From: Sue Howell
Sent: 18 April 2018 16:39
To: Anita Gardner
Subject: RE: Planning Consultation on: FG/206/17/PL

Comments from Greenspace

Further to the submission of revised Landscape Plan A-17-31-FW dwg 200-06 Rev B, I can comment as follows.

Registered: 24th January
 2018
Site Address: Land at Asda Superstore Littlehampton Road
 Ferring BN12 6PN
Grid Reference: 508801 103369
Description of Installation of a Six Pump (12 Filling Position)
Works: Petrol Filling station, Drive-to- Pay Kiosk &
 associated works including Jet Wash, Air/ Water
 Services & Vacuum Equipment

1731FW CA S0 00 00 A 200_06 S4 B Landscape Plan

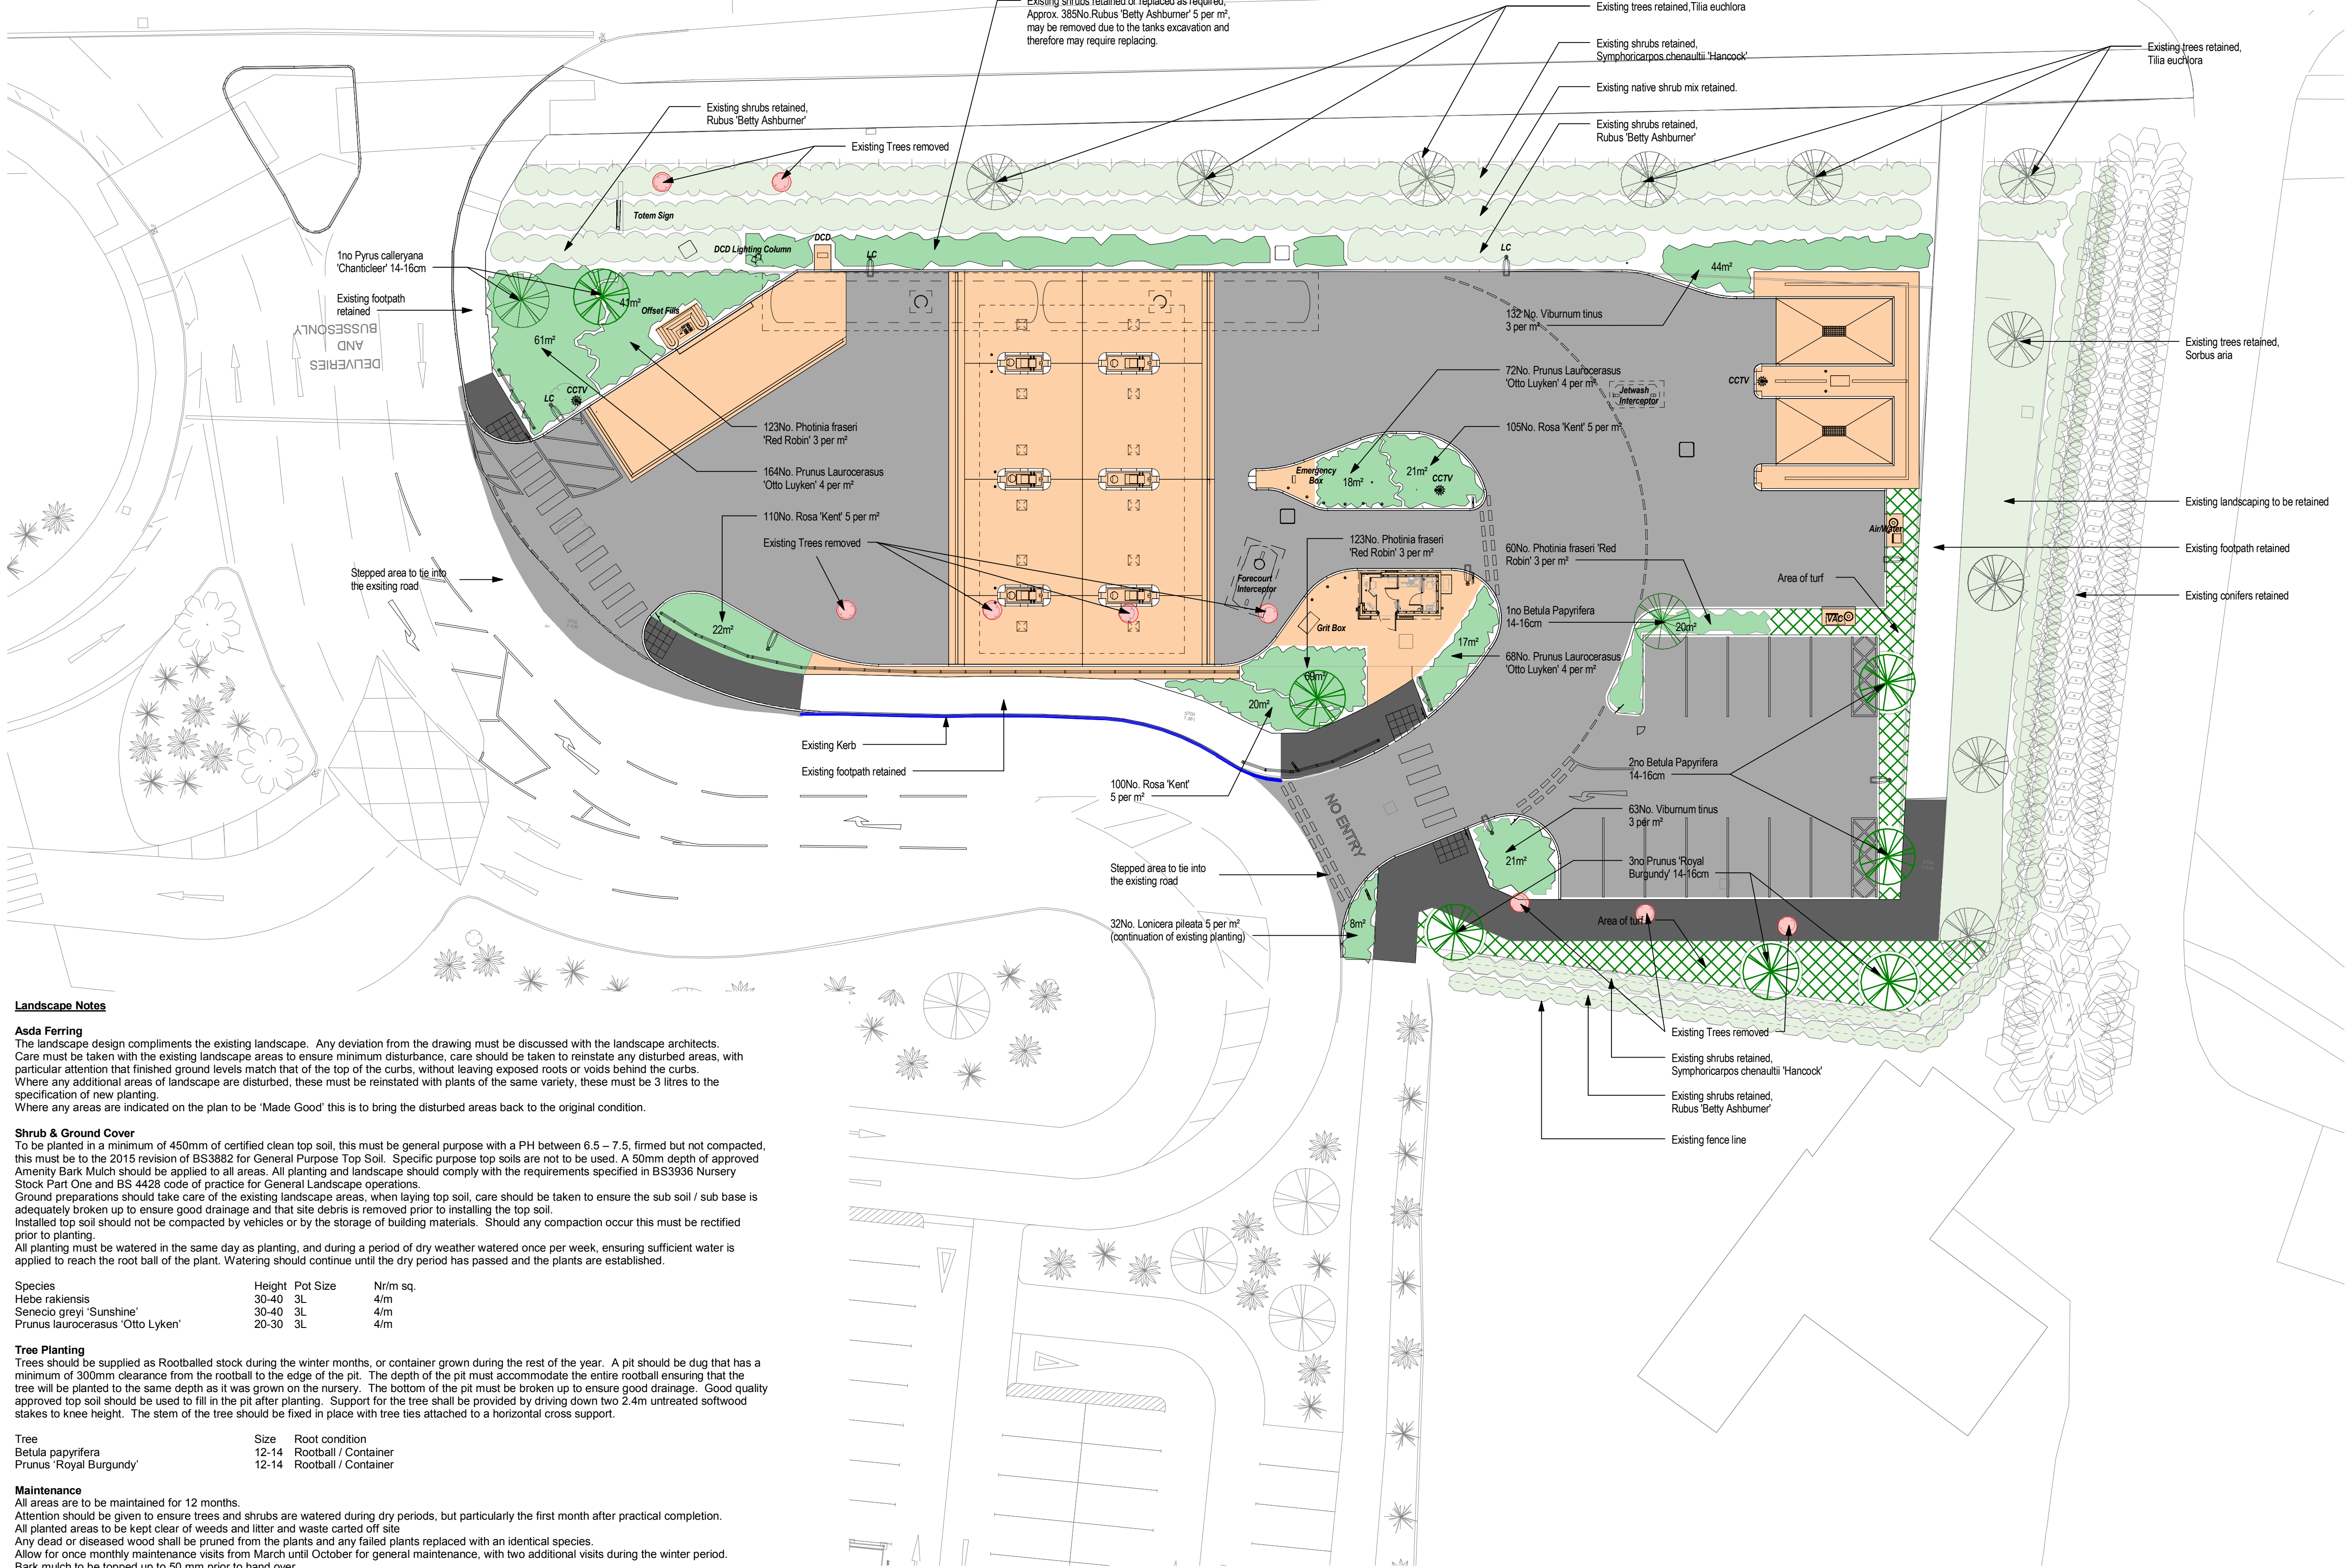
Before I formally process the plan can the green cross hatching be included in the key?

Further to the submission of Landscape Plan A-17-31-FW dwg 200-06 Rev A, I can comment as follows.

The proposed site contains an existing and establishing planting scheme implemented at the time of the ASDA store. This planting is establishing well and contains a mix of trees and shrubs both evergreen and deciduous which in context are adding value to the location. This planting appears to have been disregarded within the proposals in particular the hedging to the south eastern boundary which is to be lost to a pathway with the proposals as shown. Juvenile yet establishing trees also in this location and within an existing central island planting bed will also be lost if the proposals go ahead as detailed.

The proposed planting scheme contains plant species which would be considered more ground cover ie Hebe and Senecio rather than adding landscape structure planting, without any screening value. The trees indicated are also at a smaller size at 12-14cm girth to those in existence.

My recommendation is that the proposed landscape scheme is inadequate regarding what would need to be removed in order to implement these proposals. The planting proposals are not replacing on a like for like basis and is providing no mitigation to compensate for the new use of this area. These proposals will cause impact to local residents and will also be seen from the wider area particularly from the SDNP to the north. Further landscape detail should be considered and incorporated into this proposal in order for the landscape value and the impact on its surrounds not to be compromised.

I would recommend an objection on landscape grounds to the proposals at present which could be overcome with a more thoughtful and complete landscape proposal. I would recommend that further landscape detail is submitted for approval or conditioned along with any decision.

The revised landscape scheme has addressed our previous comments from Rev A dwg. The revised proposals have considered the establishing planting scheme implemented at the time of the ASDA store. The revised scheme has now allowed for the retention of the establishing juvenile planting and has proposed a scheme that now adds to this existing. The planting and hedging to the south eastern boundary is now to be retained which is good to see. Additional trees and shrubs which are structural rather than just groundcover have also now been proposed into the scheme.

The landscaping now shown to these proposals are significantly improved and my recommendation would now be that I have no objection on landscape grounds to the proposals as shown.
